**EPC Site Plan – SEC 86<sup>th</sup> Street & Bridge Blvd SW****Applicant Comment Response Memo for:****CONDITIONS OF APPROVAL**

Project #: 2020-004098 / SI #: 2024-01284 - Site Plan – EPC

SEWER CONSTRUCTION NOTES	
I.D.#	DESCRIPTION
3	8" SEWER PIPE PER STANDARD SPECIFICATION SECTION 901
12	4" DIA. TYPE E MANHOLE PER ABCWUA STANDARD DETAIL 2102.
21	4" SEWER SERVICE PER ABCWUA STANDARD DETAIL 2125

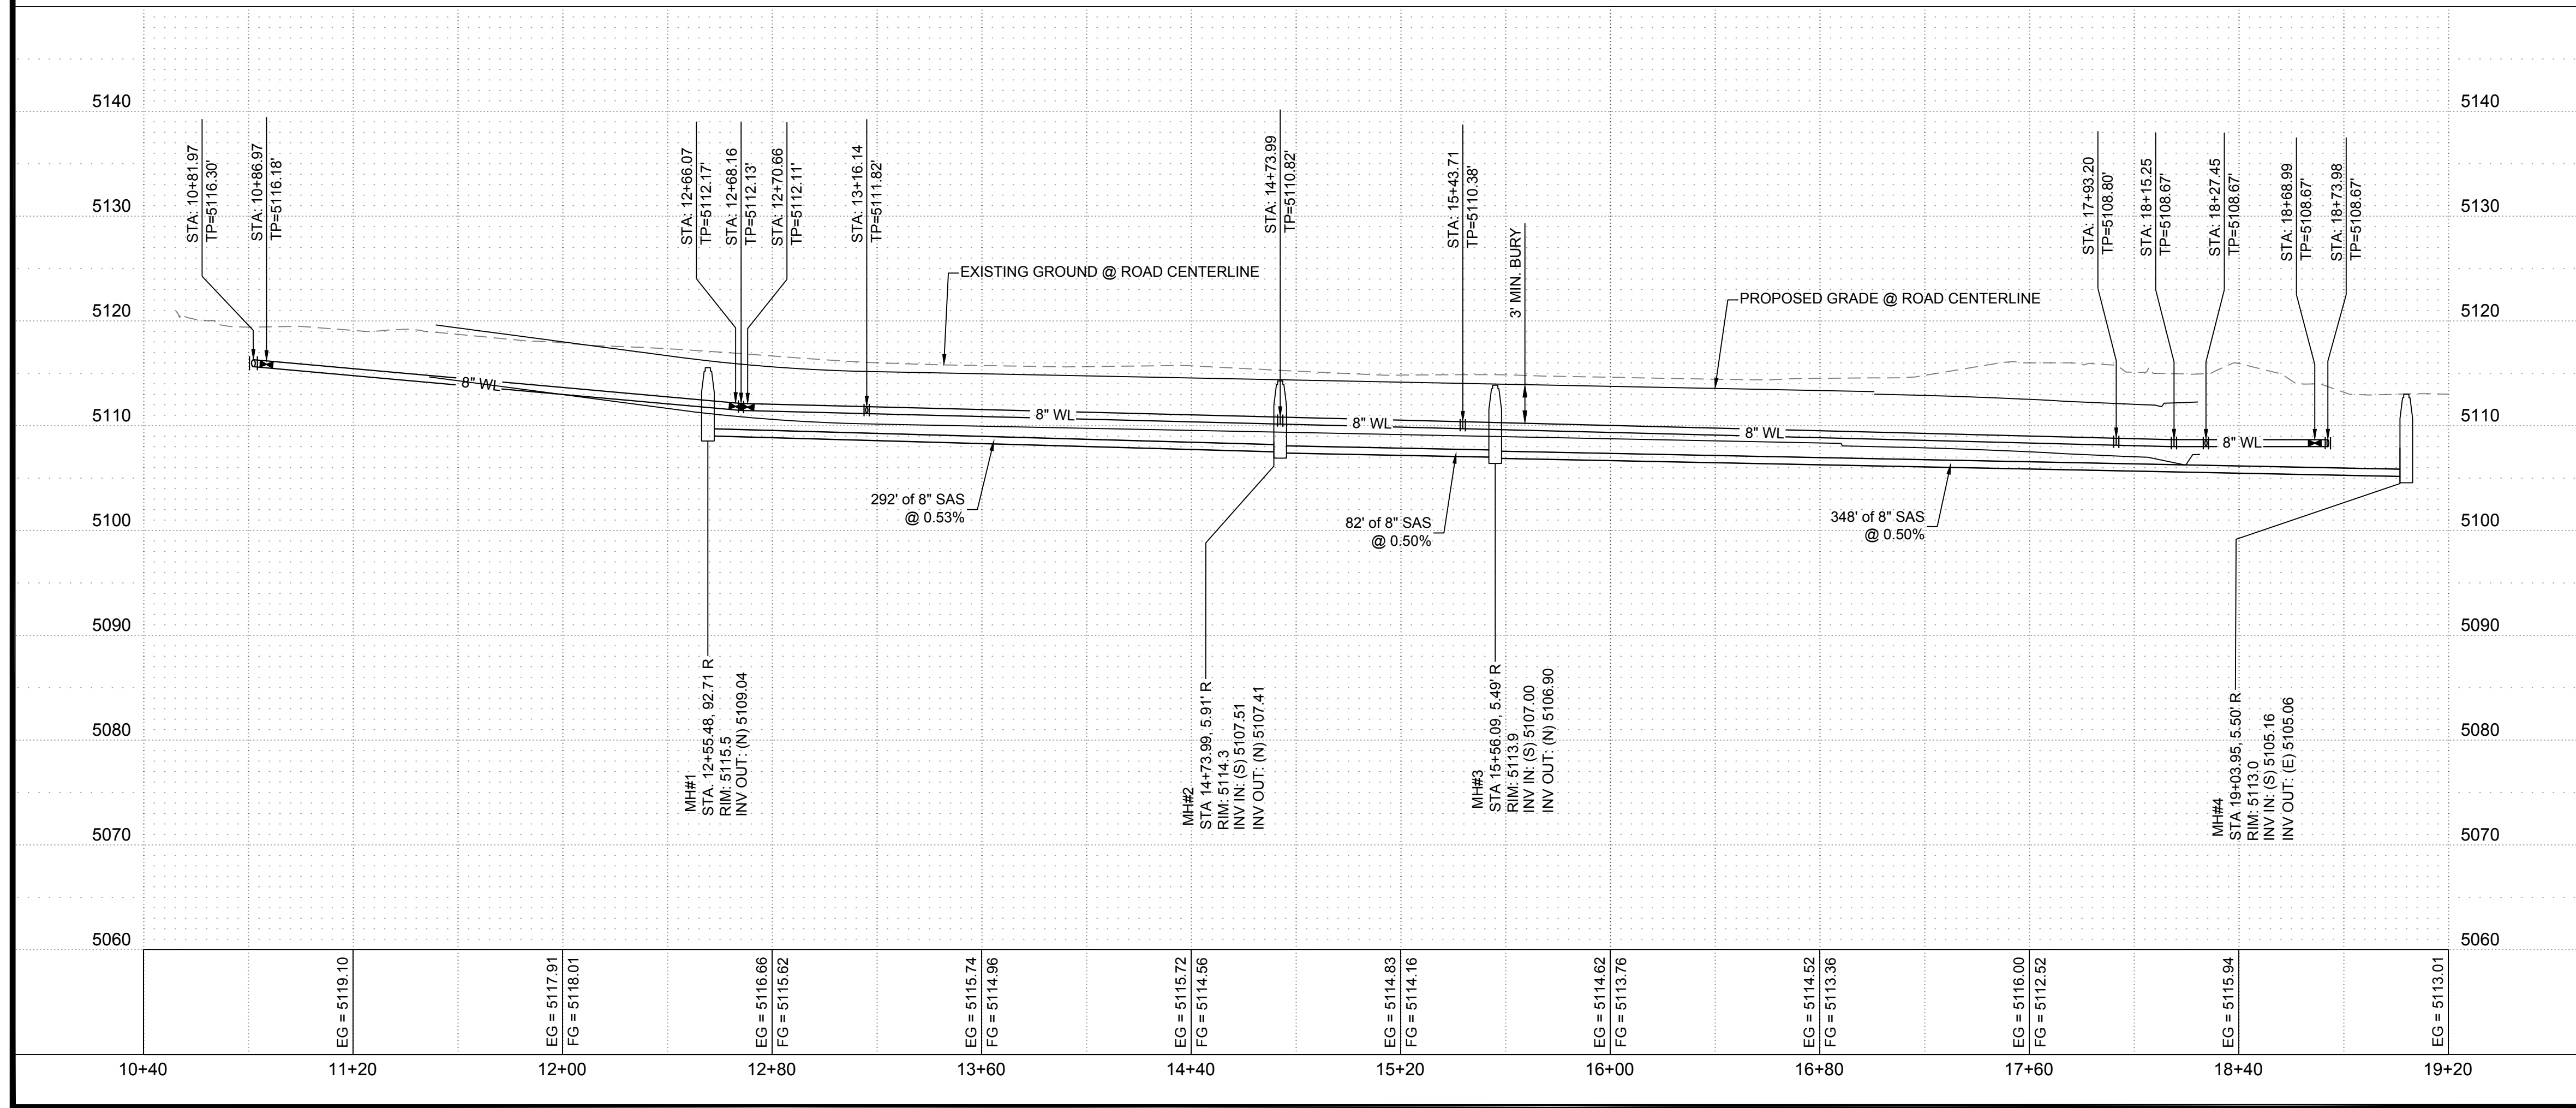
A. The word CONCEPTUAL shall be removed from the title of the sheet.

B. The NOT FOR CONSTRUCTION stamp shall be removed.

*Applicant Response – Revisions have been made.*

LS-01

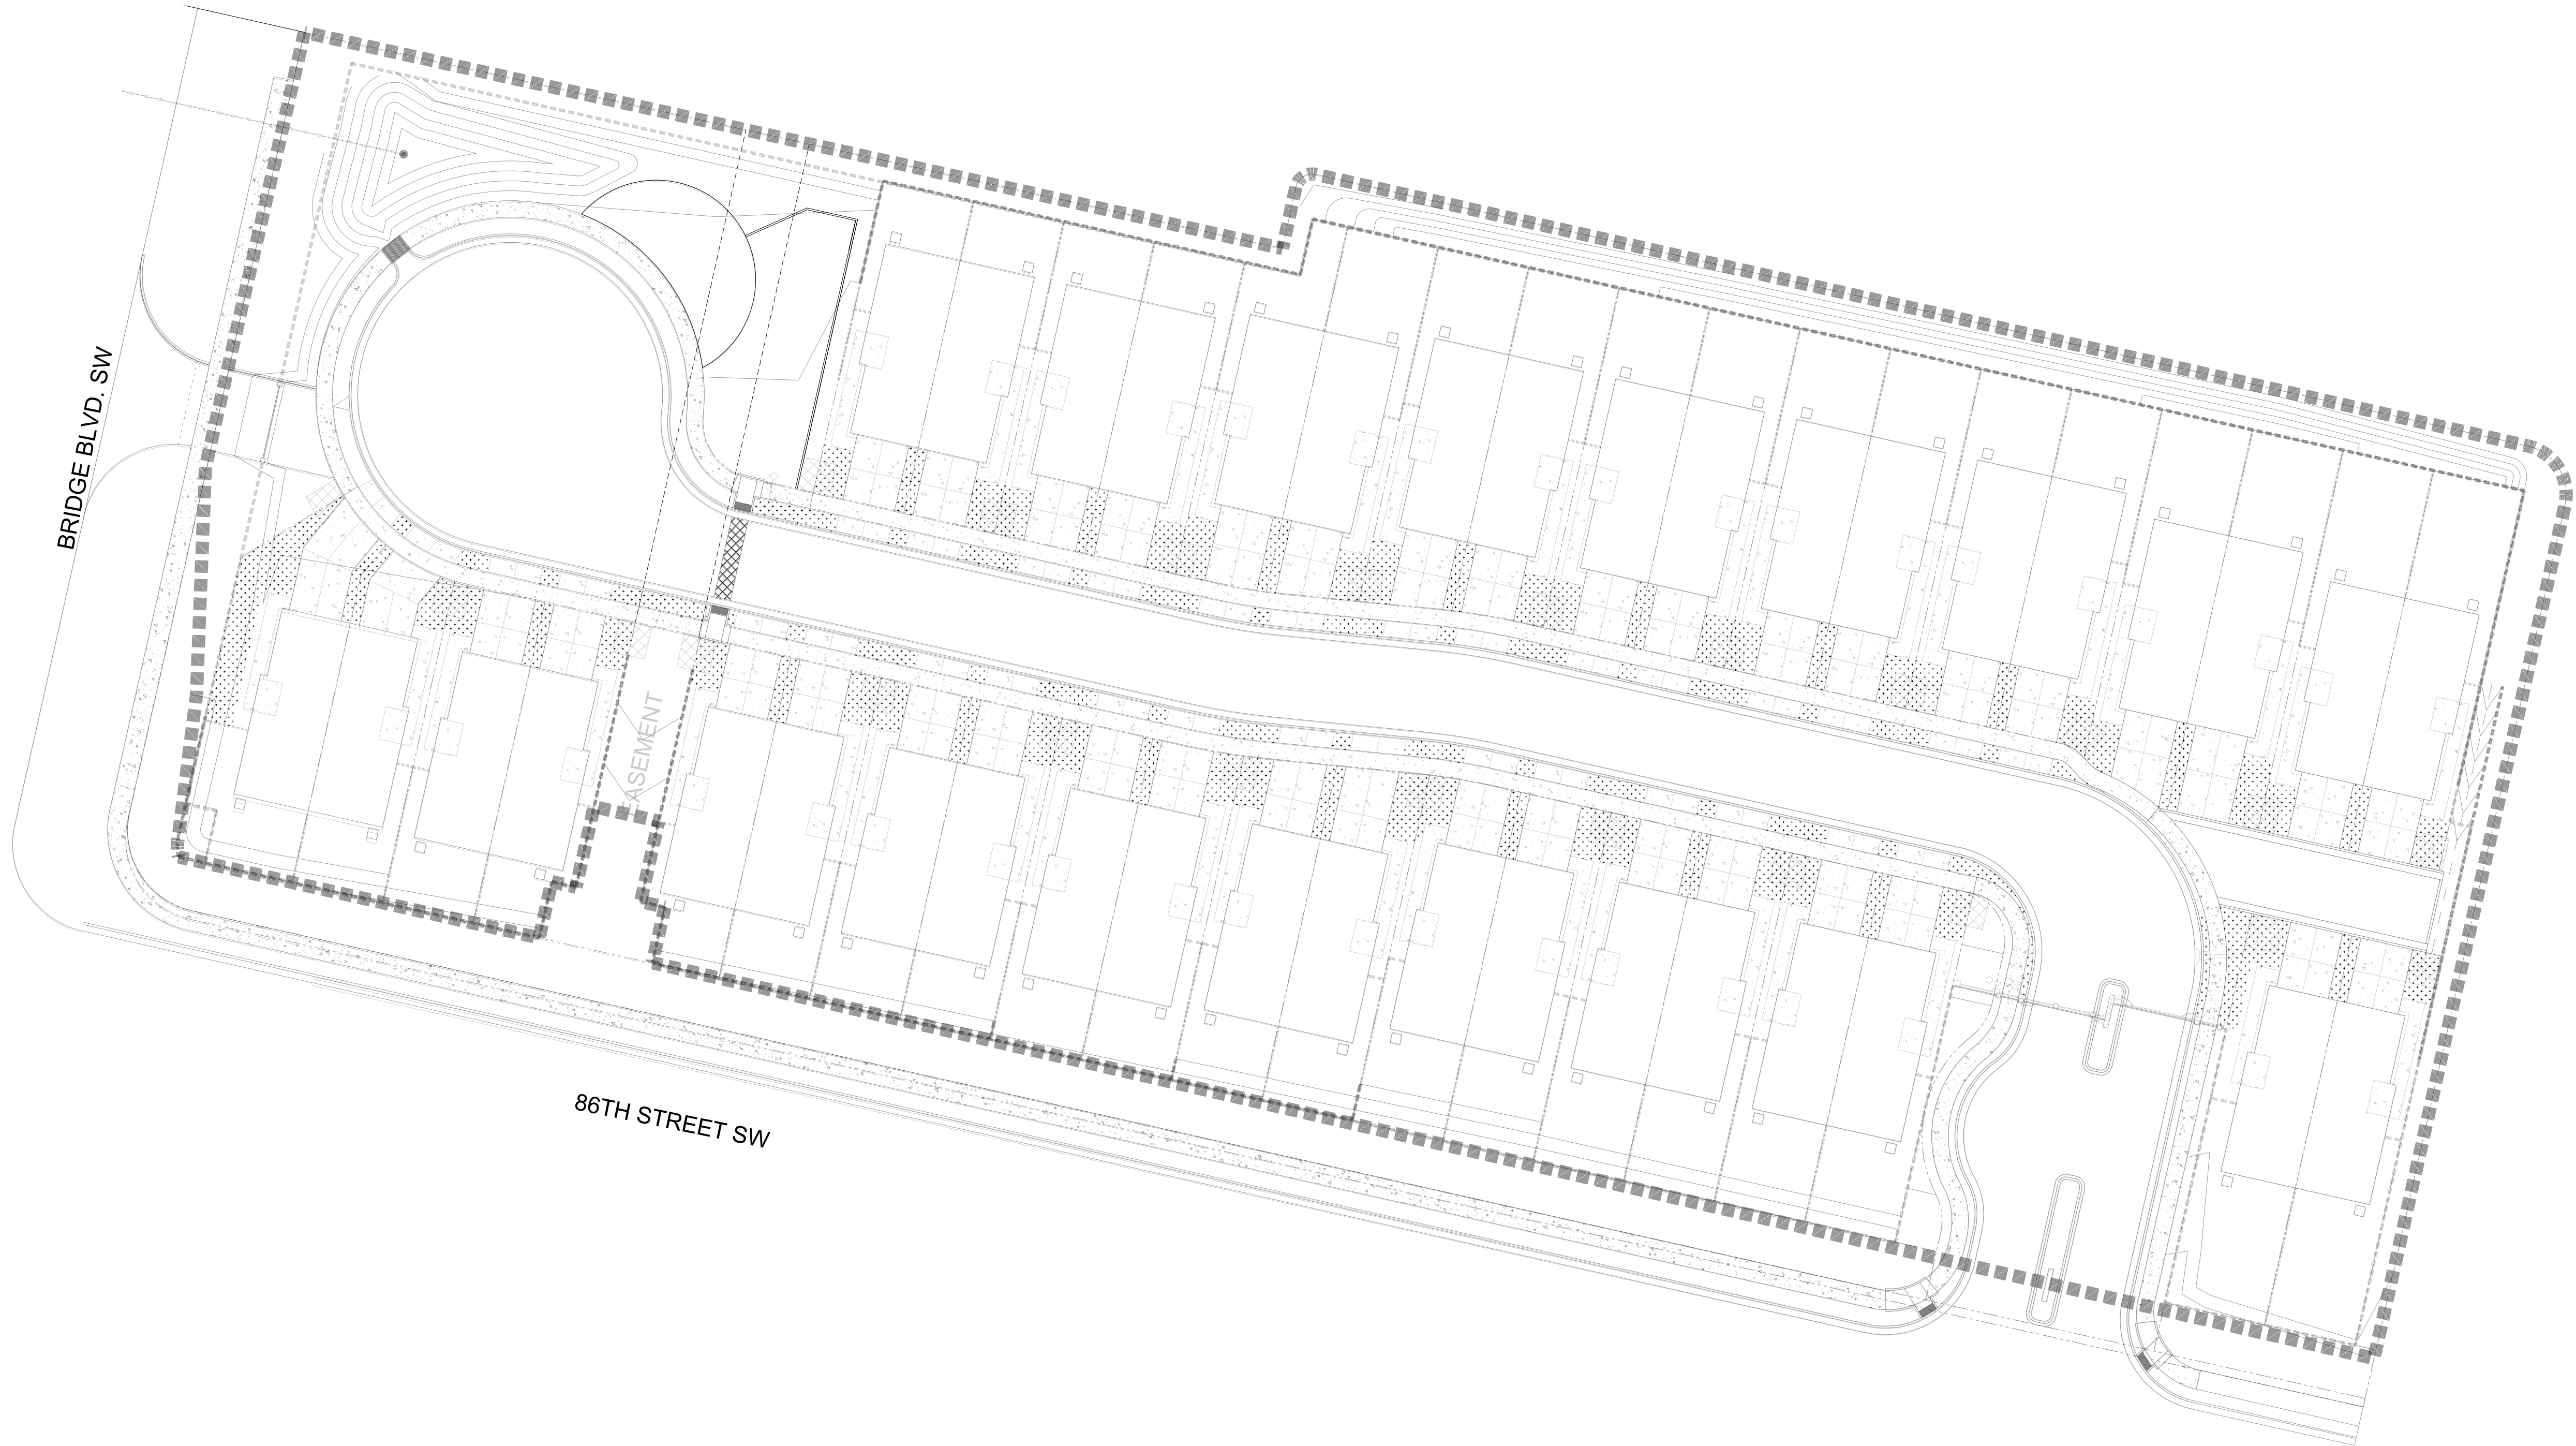
A. Street trees shall be shown along Bridge St. SW on Landscape Plan LS-01. Per Street Tree Ordinance 6-6-2-4, street trees are required every 25' on-center for those parts of the lot abutting a major street, a major local street, or another street where street trees are required. Bridge Blvd. SW is an Urban Major Collector, and street trees are required.

*Applicant Response – Additional trees and spacing calculation have been provided on the Landscape Plan.*

REAR ELEVATION
1/8" = 1'-0"

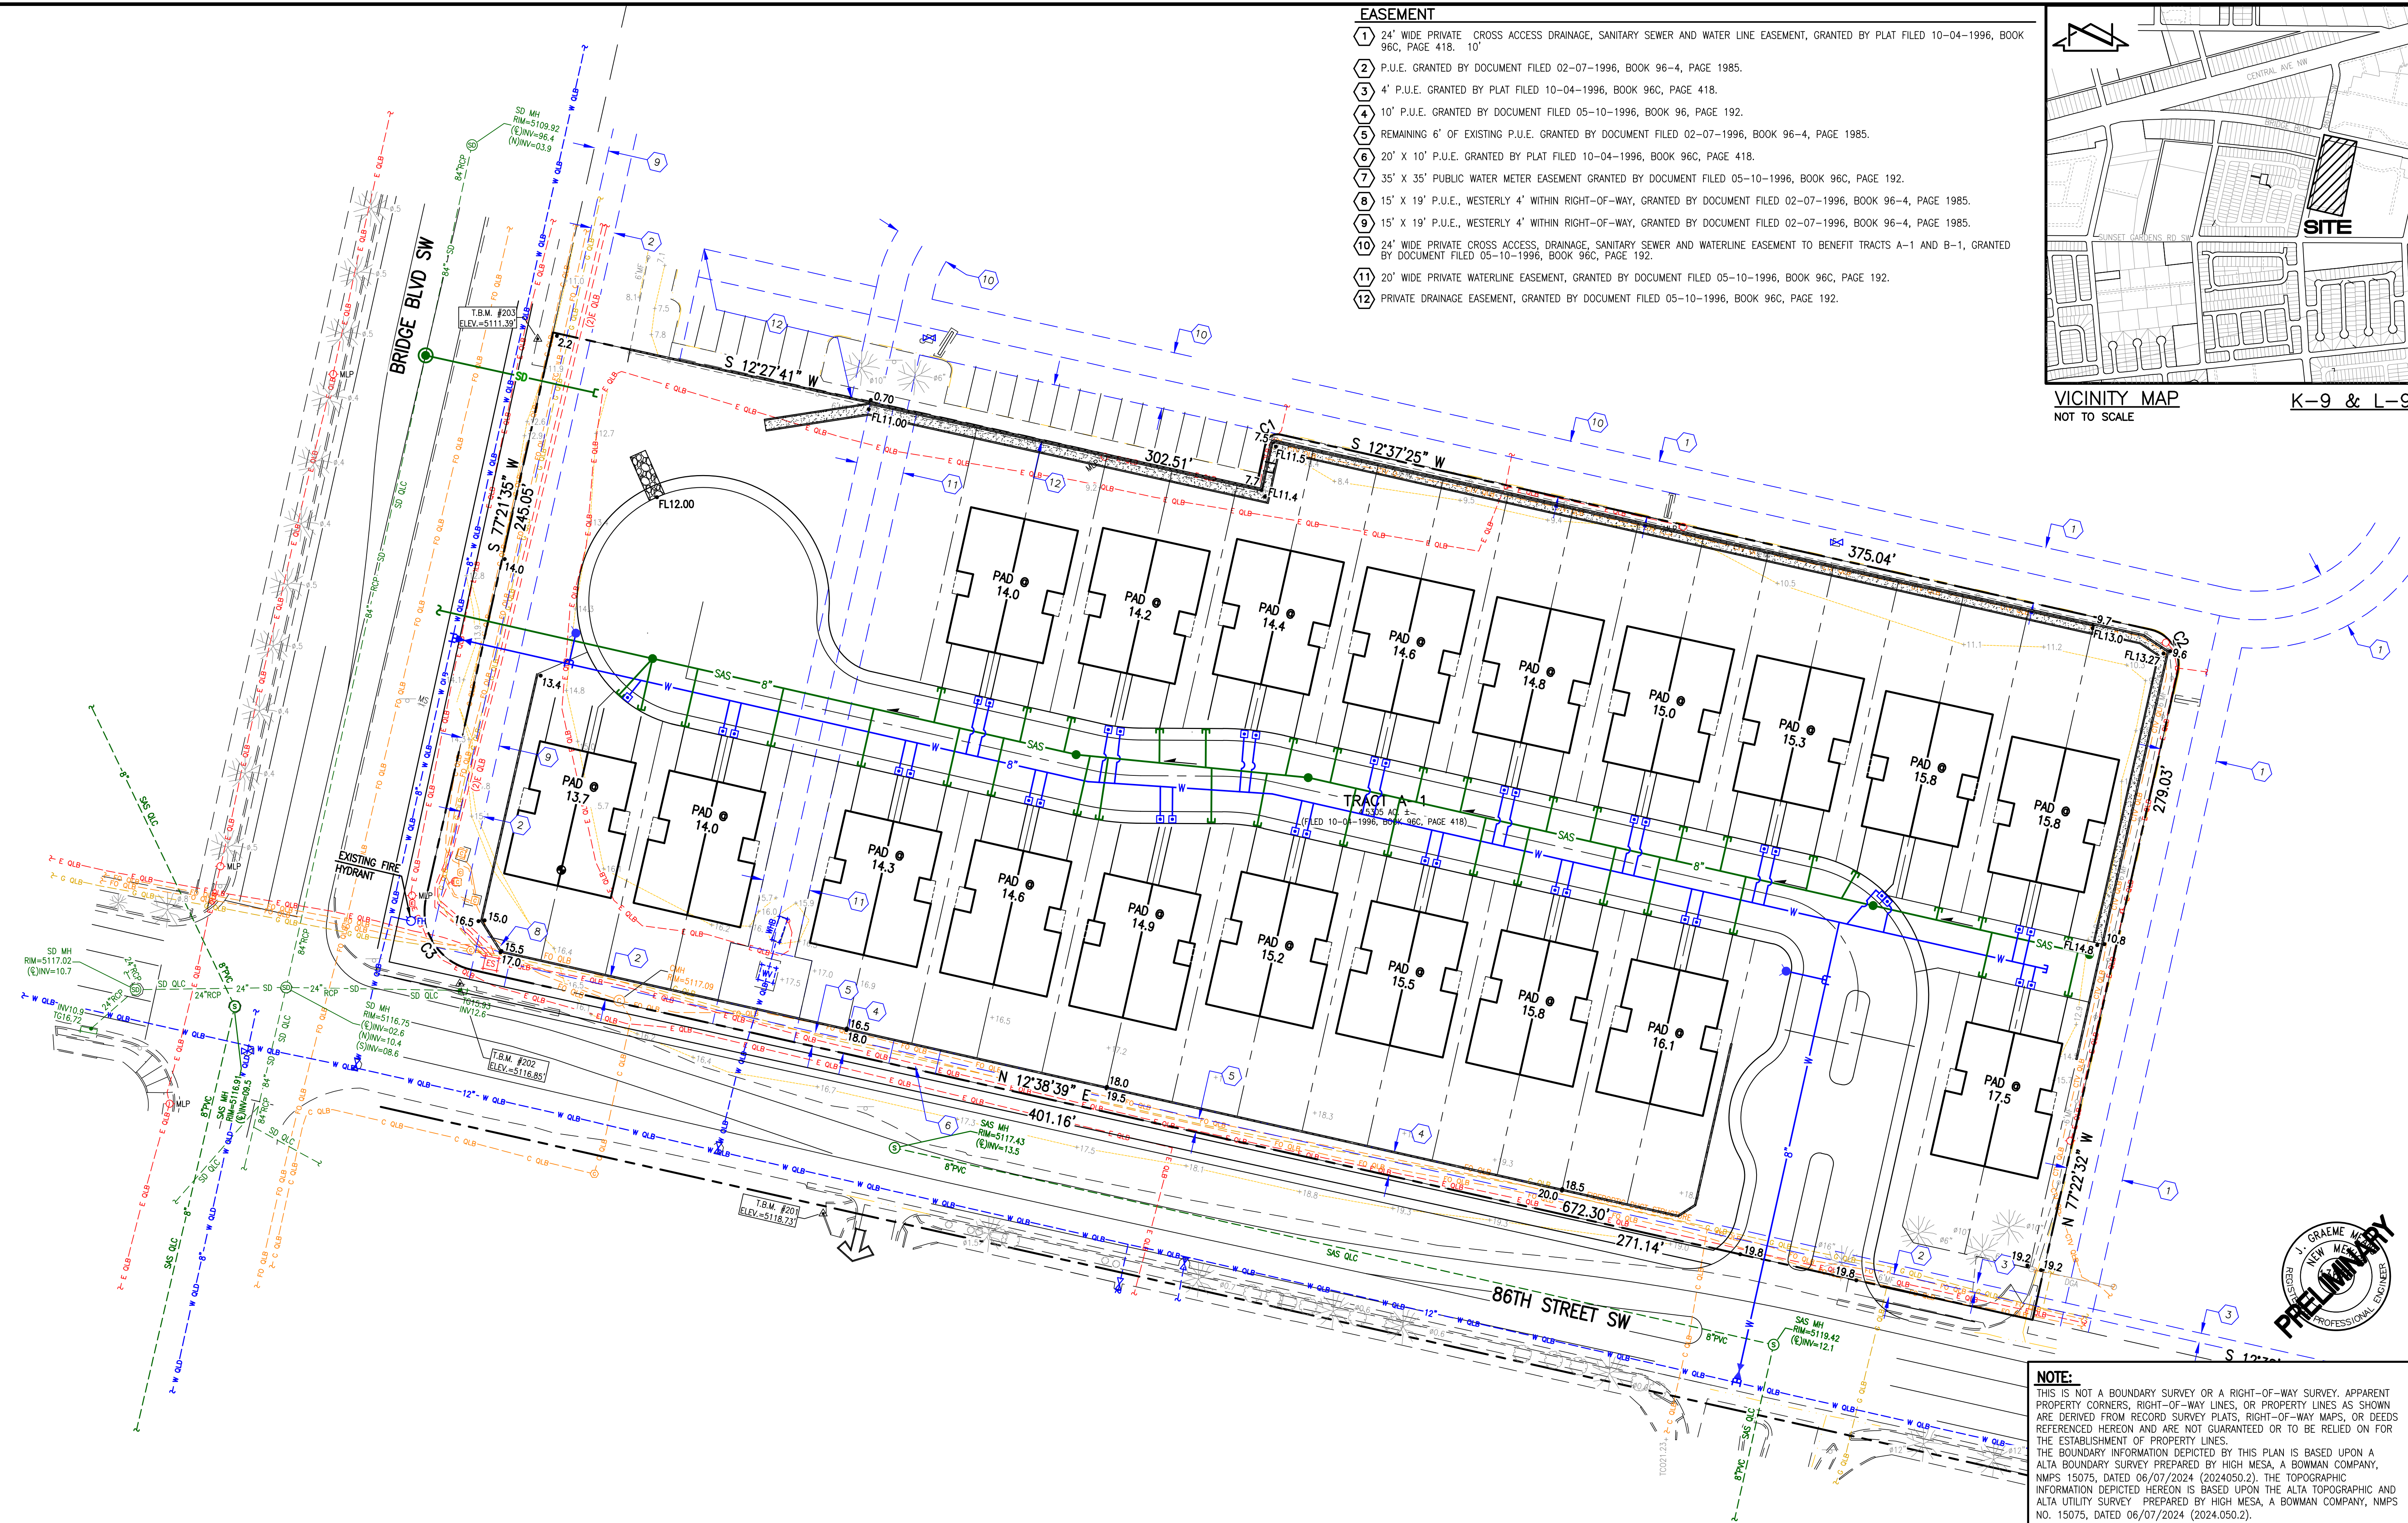
11. Elevation: The windows and rear sliding glass door shall be identified on the elevation plan.

*Applicant Response – Notations have been added for sliding glass doors and window types.*
